From: Faye Hammer <fhammer@ardent-ce.co.uk>
Sent: 04 March 2022 10:55
To: Nick Sutton; Richard Phillips
Cc: ben.howard@i-transport.co.uk; Richard Nordgreen; Phil Curwen; Surinder Jagdev; Rajvinder Jagdev; Neil Crawford; Matthew Williams
Subject: RE: Former Victoria PH, 32 North Hyde Road and rear garage court areas accessed from Sandow Crescent, Hayes - 21432/APP/2021/4649

Please see below response to the Water and Flood Management Officer comments.

DRAWING NAME: PROPOSAL GROUND FLOOR

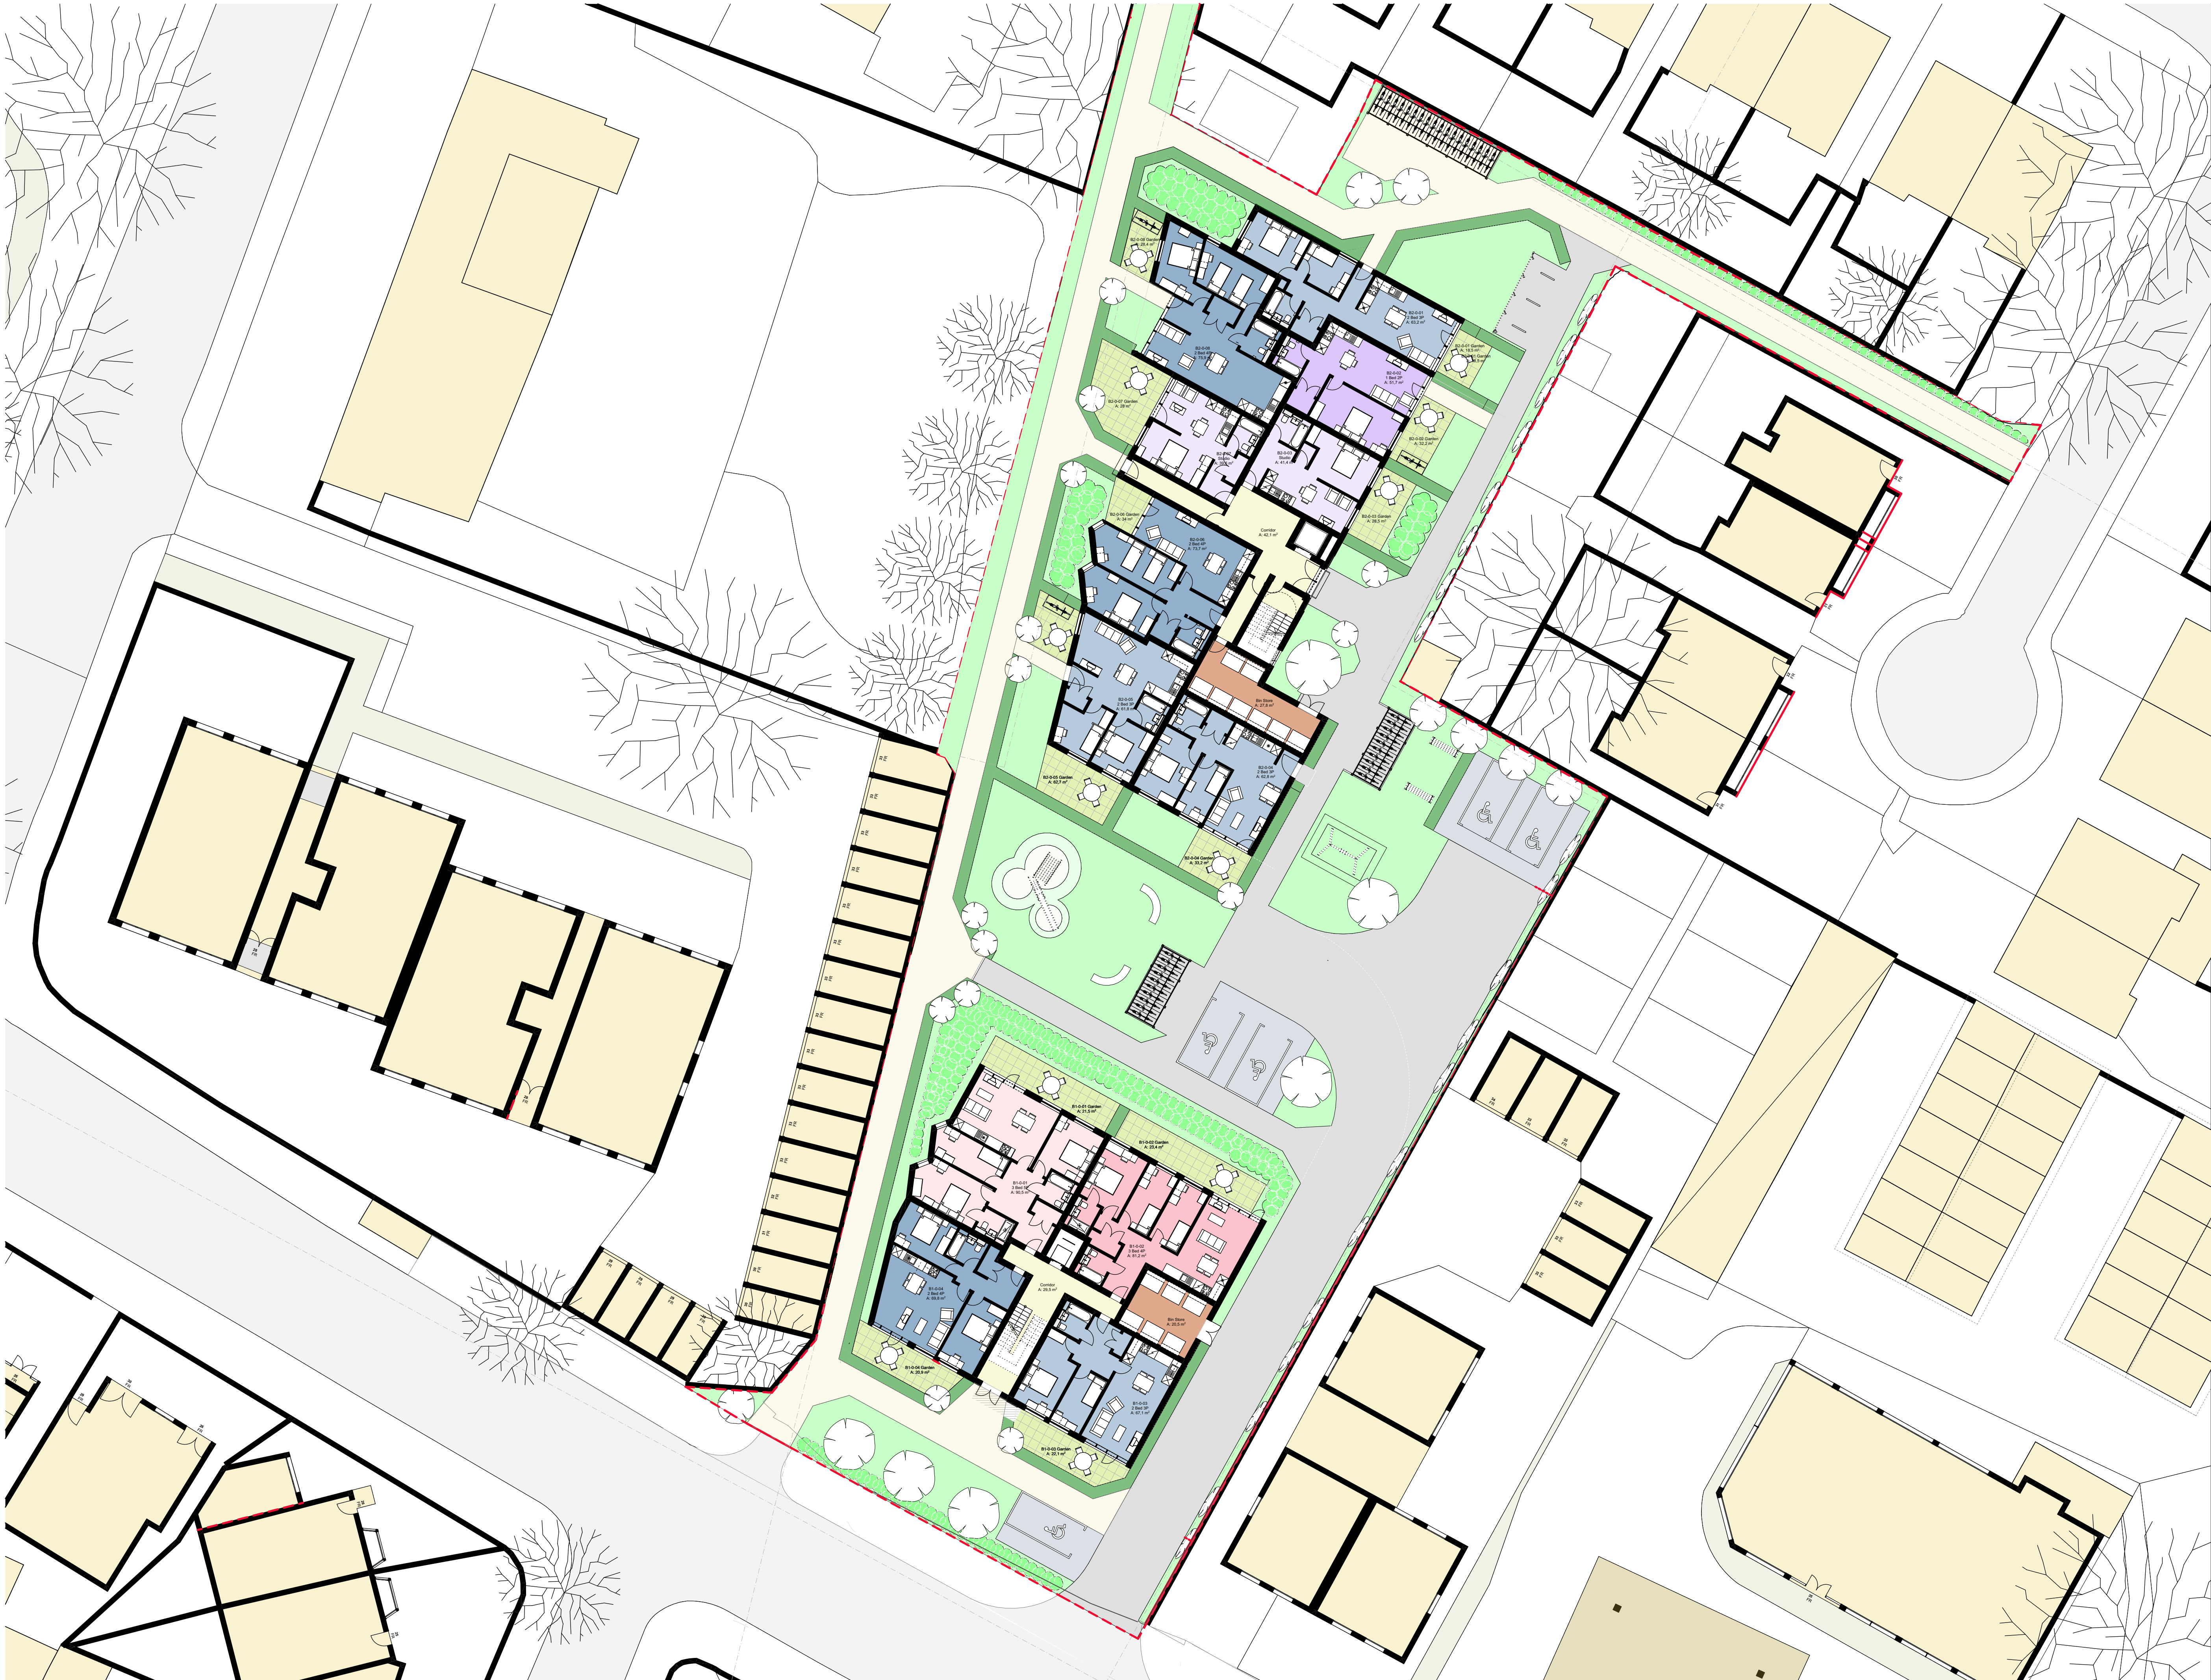
Whilst the car and cycle parking provisions comply with the London Plan and DMT6, however the vehicle access is shown without pedestrian visibility splays. The applicant is proposing to utilise the existing vehicle access however this is a new build and higher standards of design and safety are required to be applied and therefore the existing vehicle access will need to be moved to provide pedestrian visibility splays on both sides of the vehicle access.

For pedestrian safety reasons in all new vehicle accesses, it is necessary to maintain within the site areas measuring 2.4m by 2.4m, with no obstruction more than 0.6m high, either side of where the vehicle access meets the back edge of the footway, known as pedestrian visibility splays, within which unobstructed visibility is available for drivers to see and be seen by pedestrians on a footway to avoid a potential hazard in time. The splays must be wholly within the site's curtilage and physically protected (dwarf wall/ped gate) from being driven over thereby undermining their necessity.

The relocating of the vehicle access will require the reappraisal of where the applicant has suggested moving the pedestrian island, the applicant will be required to robustly demonstrate where the island can be safely sited and still meet pedestrian crossing requirements.

The standalone disabled parking bay is located too close to the access bellmouth and would create obstruction, parking bays should be at least 5m from the access bellmouth.
